Reference: WC853-05F01(rev0)- WE Letter

**RE: 80-88 REGENT STREET, REDFERN
LETTER FOR PEDESTRIAN WIND ENVIRONMENT MITIGATION**

Windtech has reviewed the amended design drawing set prepared by Bates Smart, received 18 January 2019 (Doc. Ref.:190118_Iglu_80-88 Regent Street_Drawingset) and the landscape drawings prepared by 360 Degrees, received 18 January 2019 (Doc. Ref.: Appendix J_Landscape Design Report and Plans).

Elevation South

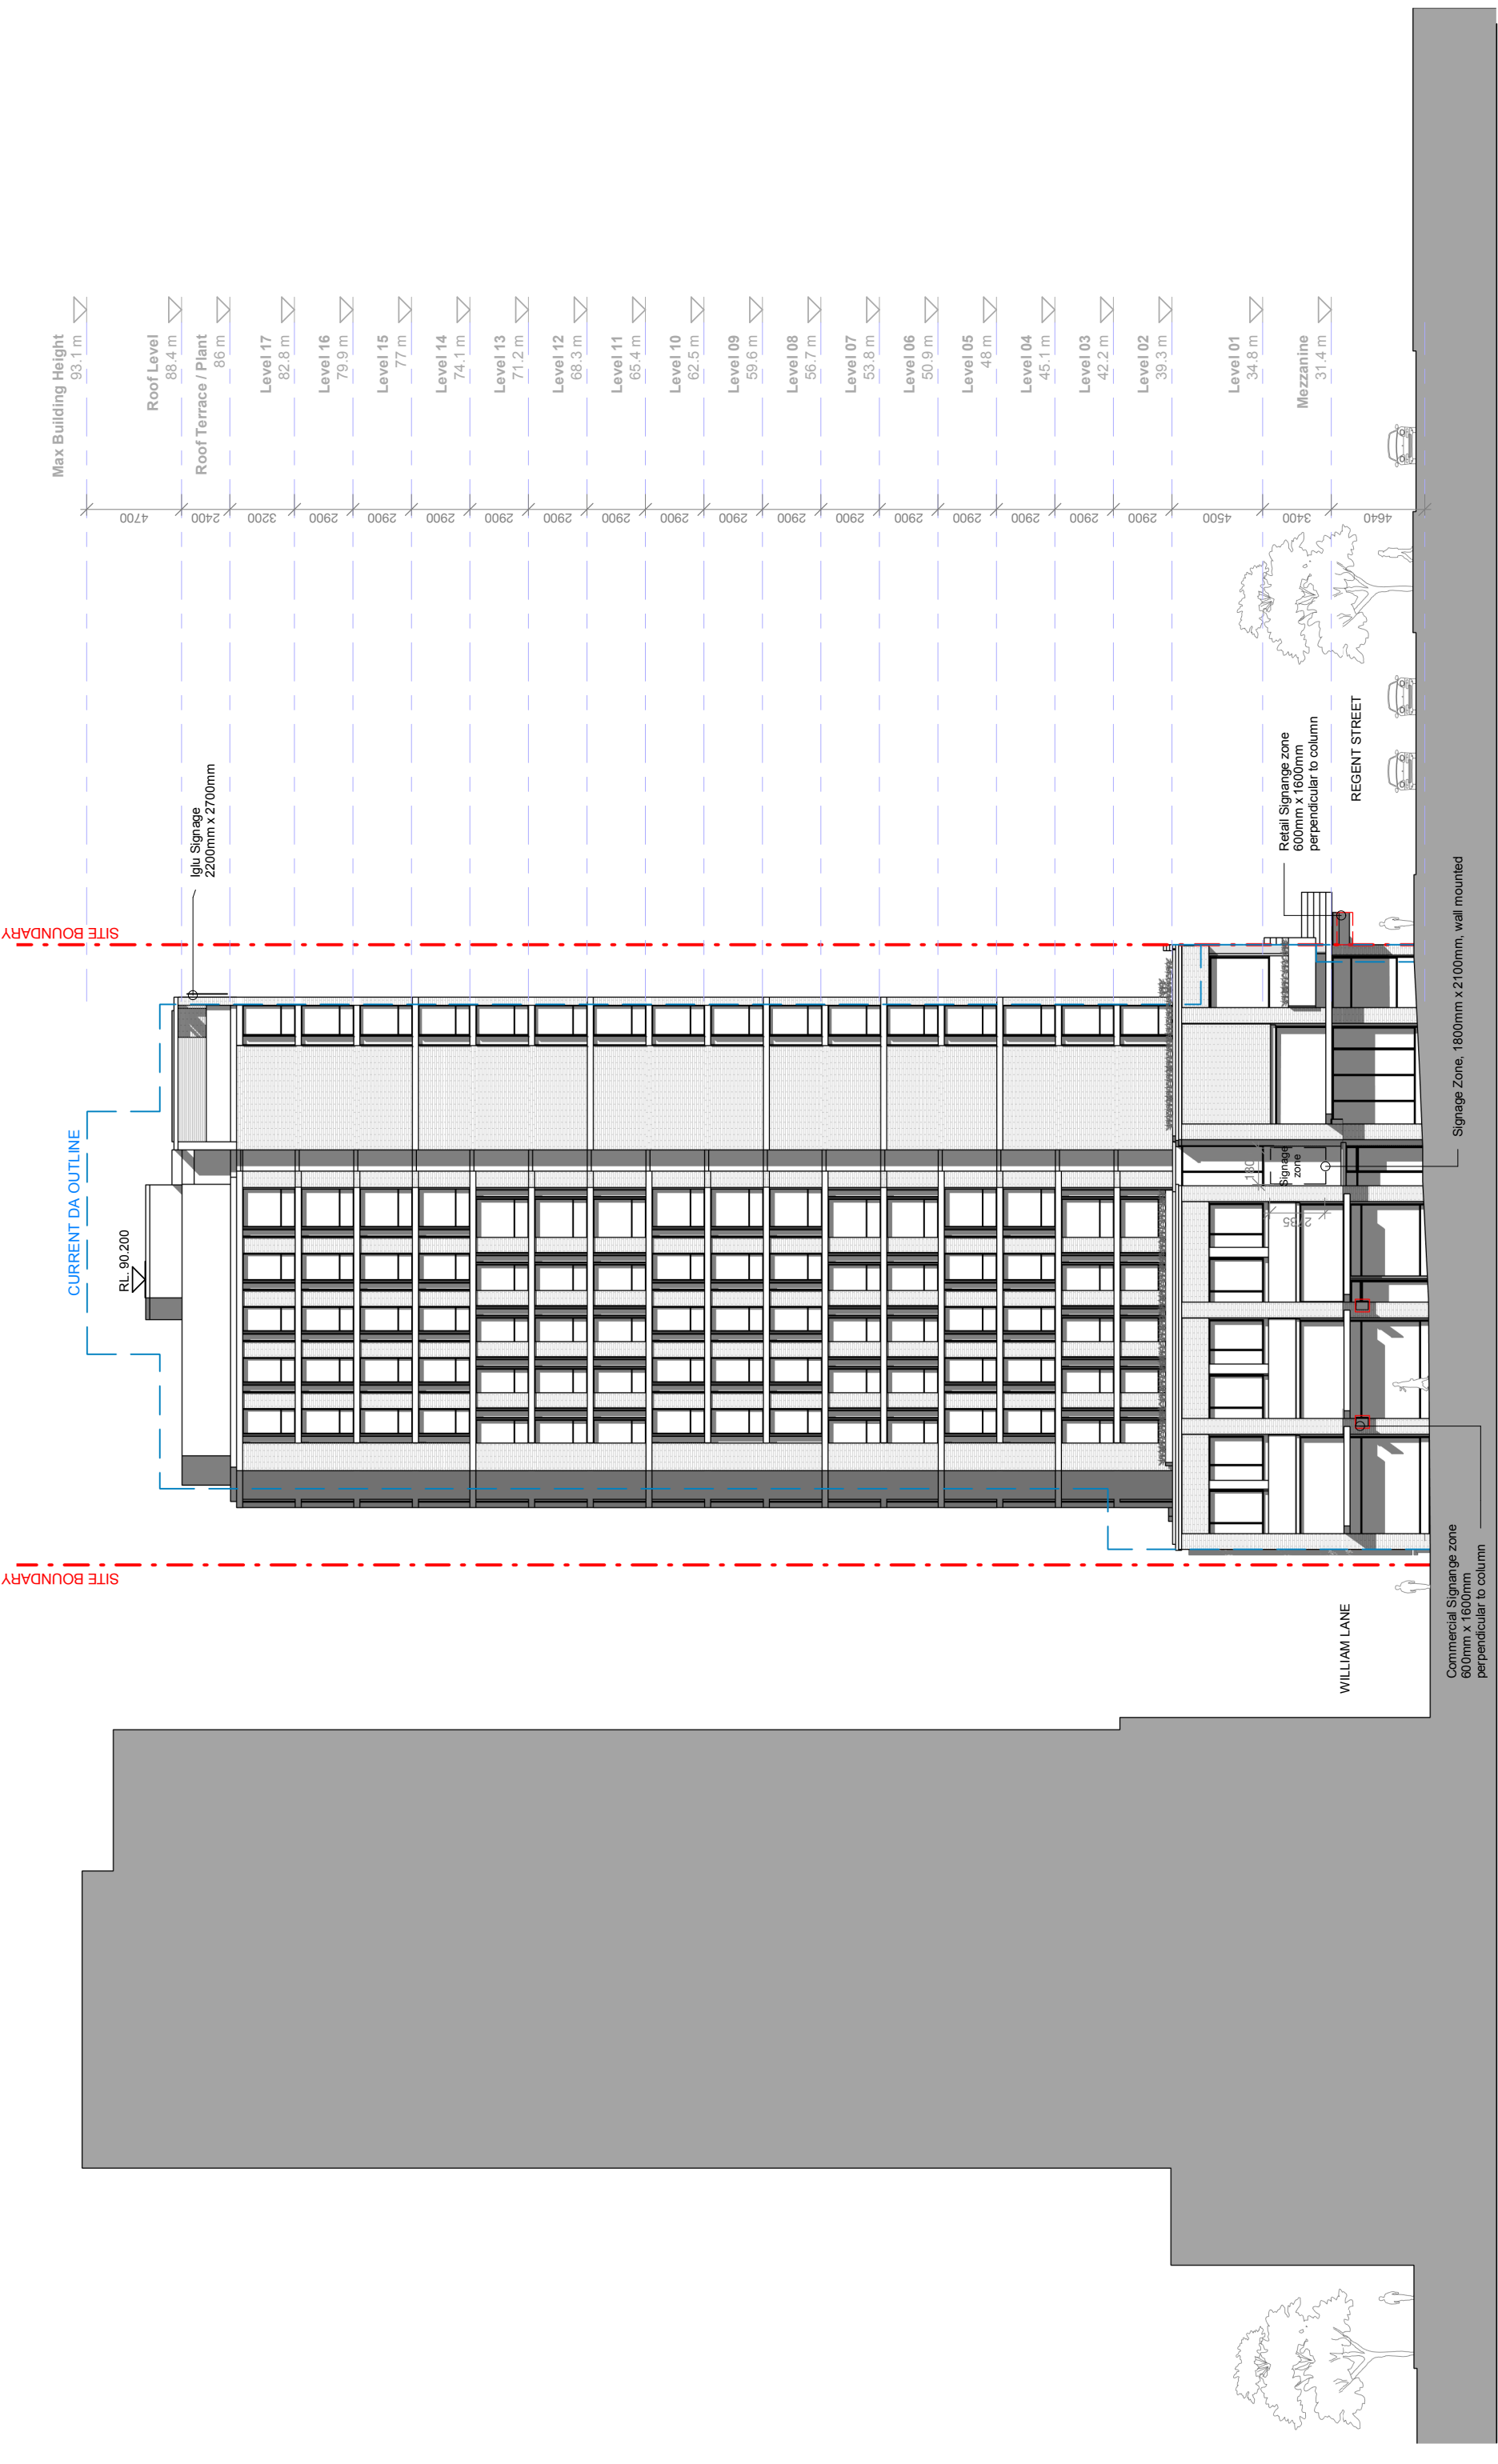
The awning along Marian Street has been amended to form a continuous, full-width awning which is impermeable to wind. Windtech is satisfied that the design presented meets the requirements of the treatment recommendation.
